**Re: Extension and alterations to Elderberry House**  
**Your ref: AL/32/20/HH**

Following the approval of the above application we have attached our application for a non-material amendment to the design, along with our amended drawing 20-05-2.01 revision D.

DRAWING TITLE
Proposed plans and elevations

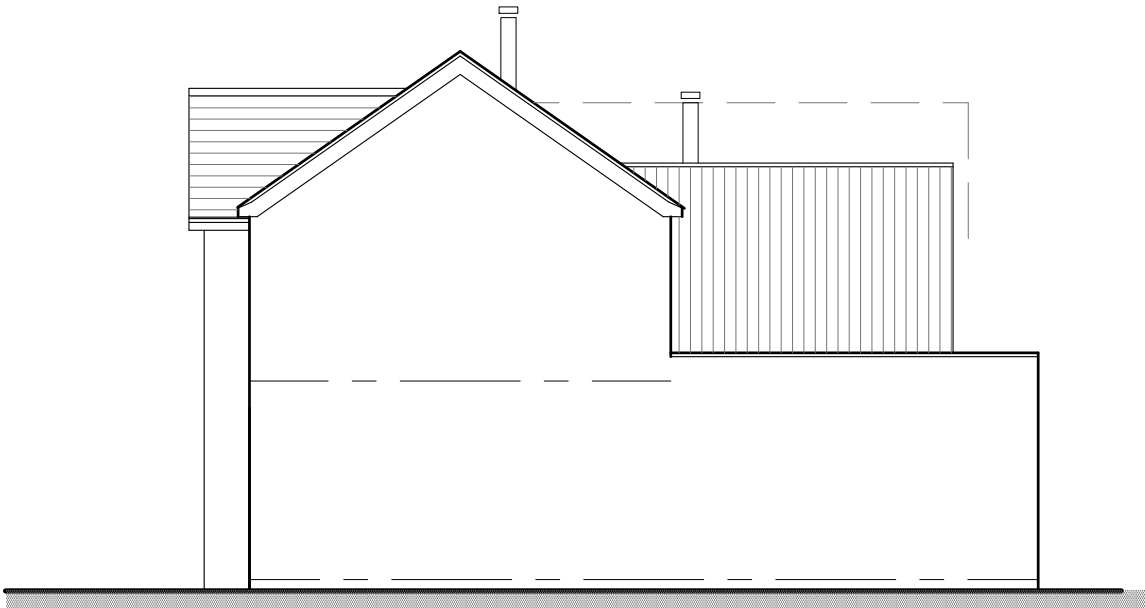
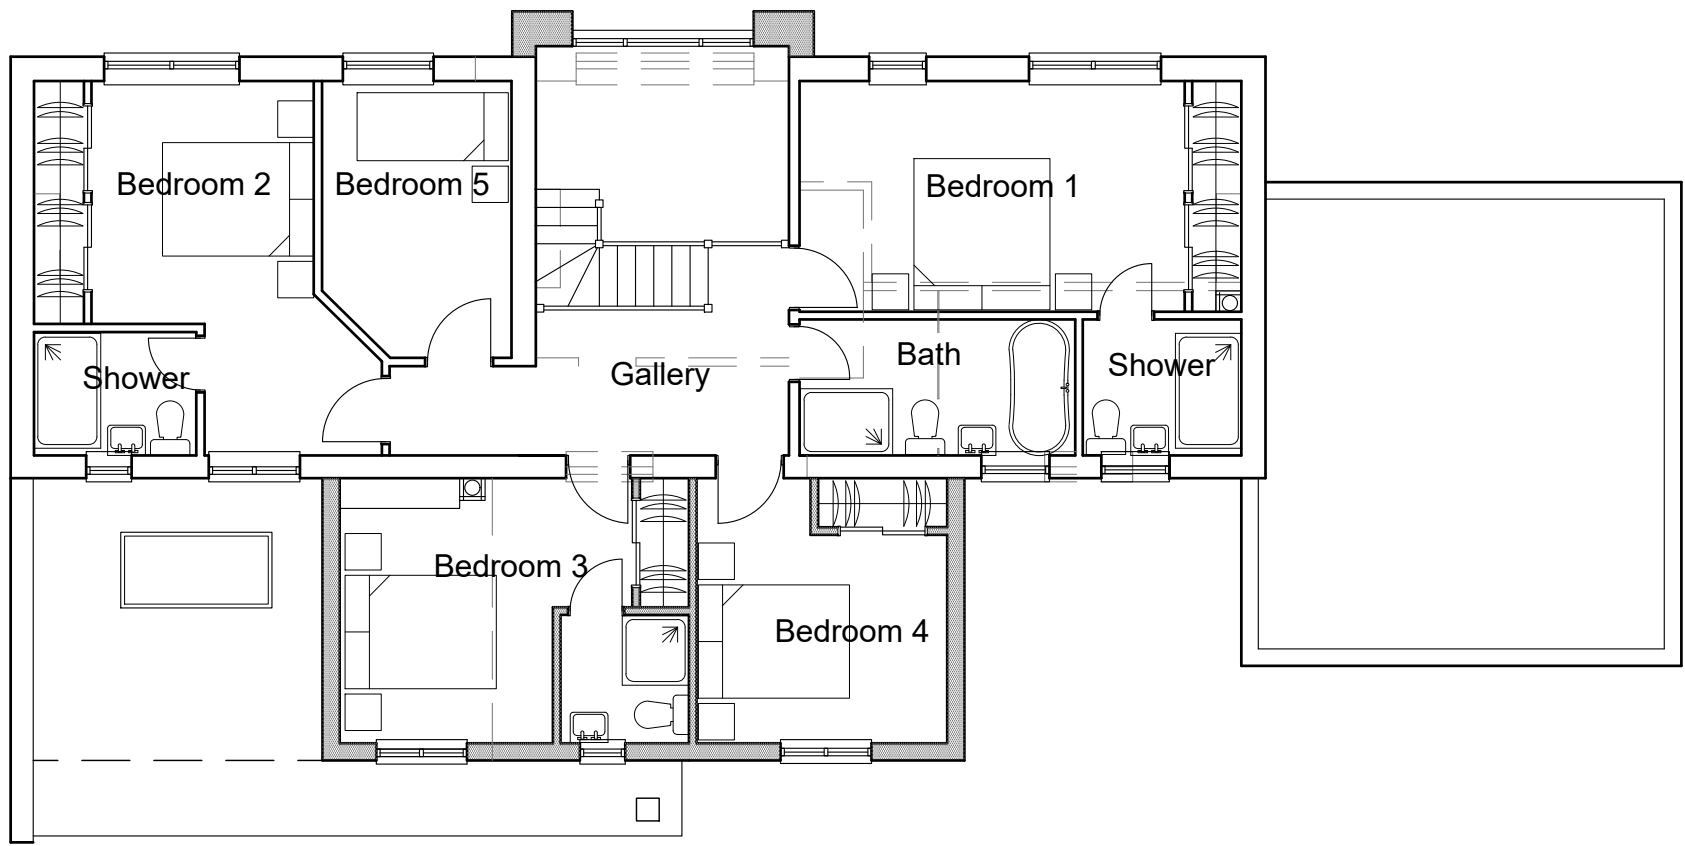
We are now proposing to clad the external walls, where indicated on the elevations, with vertical cedar boarding in place of the fibre cement boarding previously specified.
